**Planning Department
Transportation Development Services**

May 28, 2015

**Re: IL Vicino Canteen Brewhouse Kitchen Expansion
2381 Aztec Rd NE
Traffic Circulation Layout
Engineer's/Architect's Stamp dated 5-11-15 (G16-D089)**

2 Existing Site Conditions

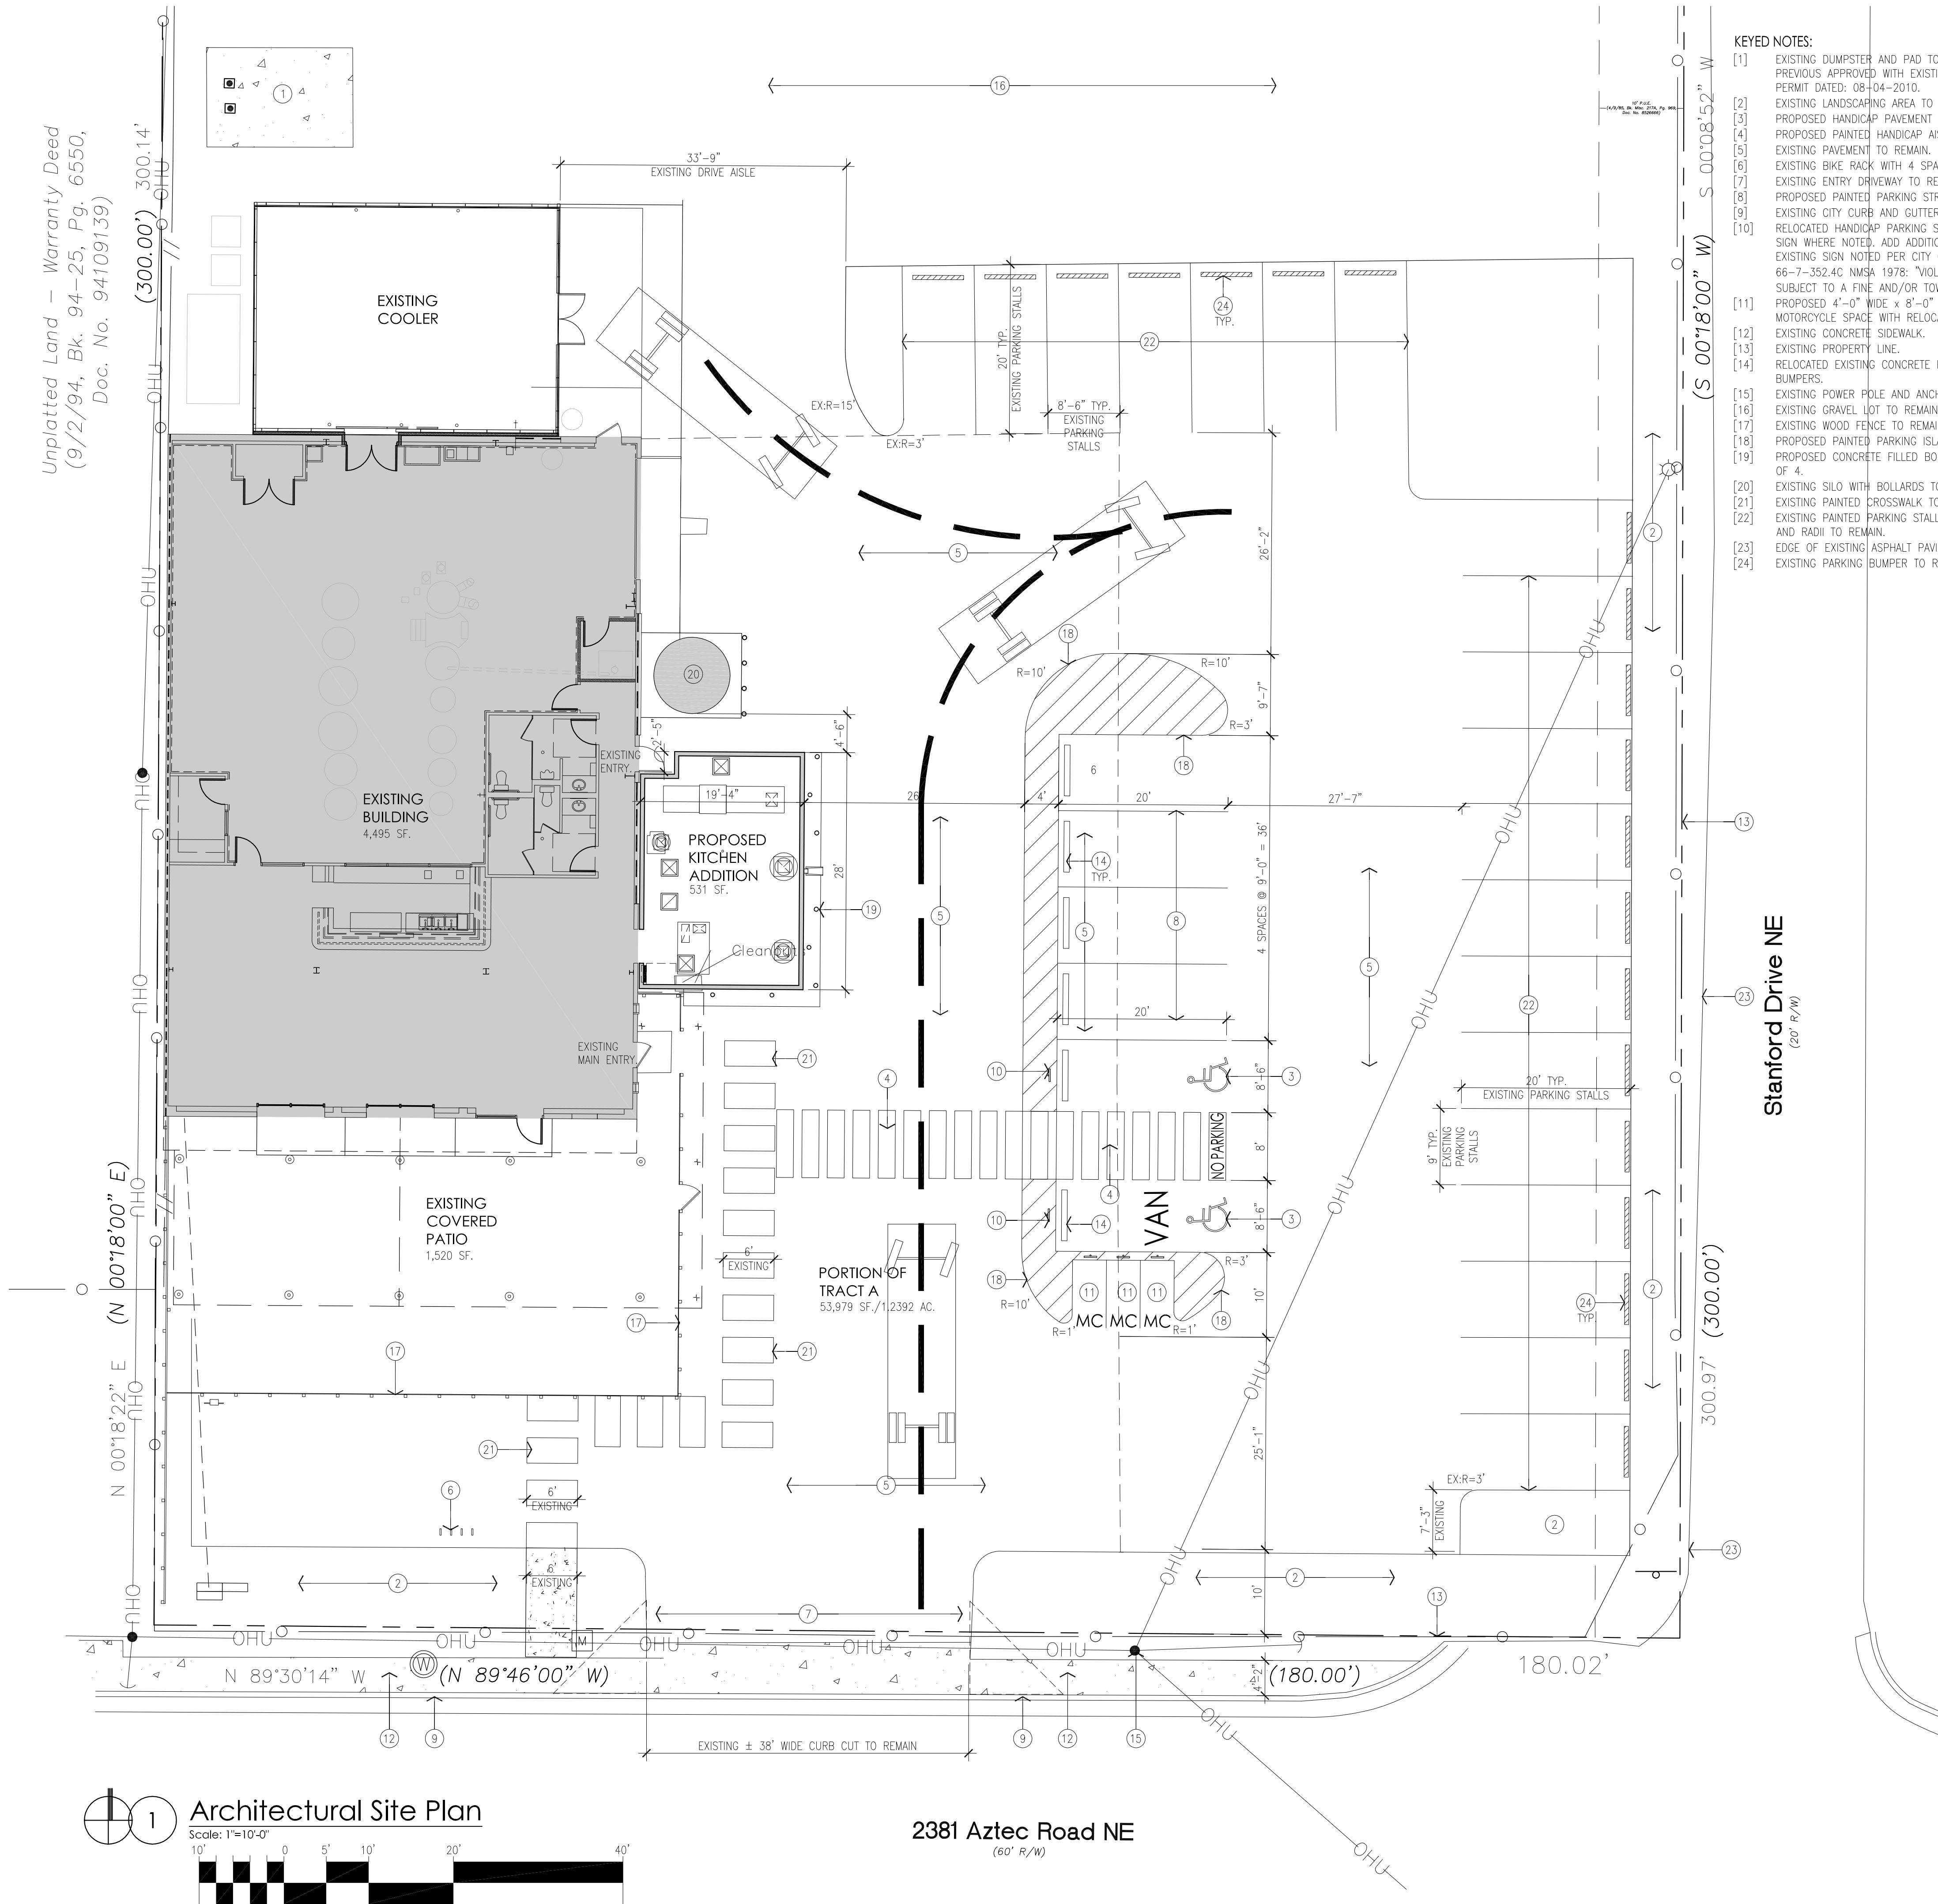
1. Please identify and dimension all existing pedestrian walkways from the public R.O.W. and from the existing parking lot. Dimension the width of the public R.O.W. sidewalk.

2. Please list the width and length of all the existing parking spaces.
3. Show and dimension all existing and proposed drive aisle widths and radii.
4. Please identify all existing parking bumpers or curb stops.

5. The ADA van accessible sign must have the required language per 66-7-352.4C NMSA 1978 **"Violators Are Subject to a Fine and/or Towing."** Please provide a detail of this sign.

6. Per the DPM, a 6 ft. wide ADA accessible pedestrian pathway is required from the public sidewalk to the building entrances. Please clearly show and dimension this pathway and provide details. Please show the limits of the existing paving and detail the pedestrian walkway.

7. Provide a min 6" or max 8" high concrete barrier curb or other acceptable barrier between landscaping and parking areas and/or drive aisles. Provide parking bumpers west of handicap parking spaces along the driving isle to provide protection for the handicap signage.

8. Design delivery vehicle route needs to be shown.
9. Service vehicle and/or refuse vehicle maneuvering must be contained on-site; provide a copy of refuse approval (if applicable).

10. Please provide a sight distance exhibit for the entrance on Aztec Rd. (see the *Development Process Manual, Chapter 23, Section 3, Part D.5 Intersection Sight Distance*).

11. Please add the following note to the clear sight triangle: "Landscaping and signage will not interfere with clear sight requirements. Therefore, signs, walls, trees, and shrubbery between 3 and 8 feet tall (as measured from the gutter pan) will not be acceptable in this area."
12. Please specify the City Standard Drawing Number when applicable.
13. Please include two copies of the traffic circulation layout at the next submittal.
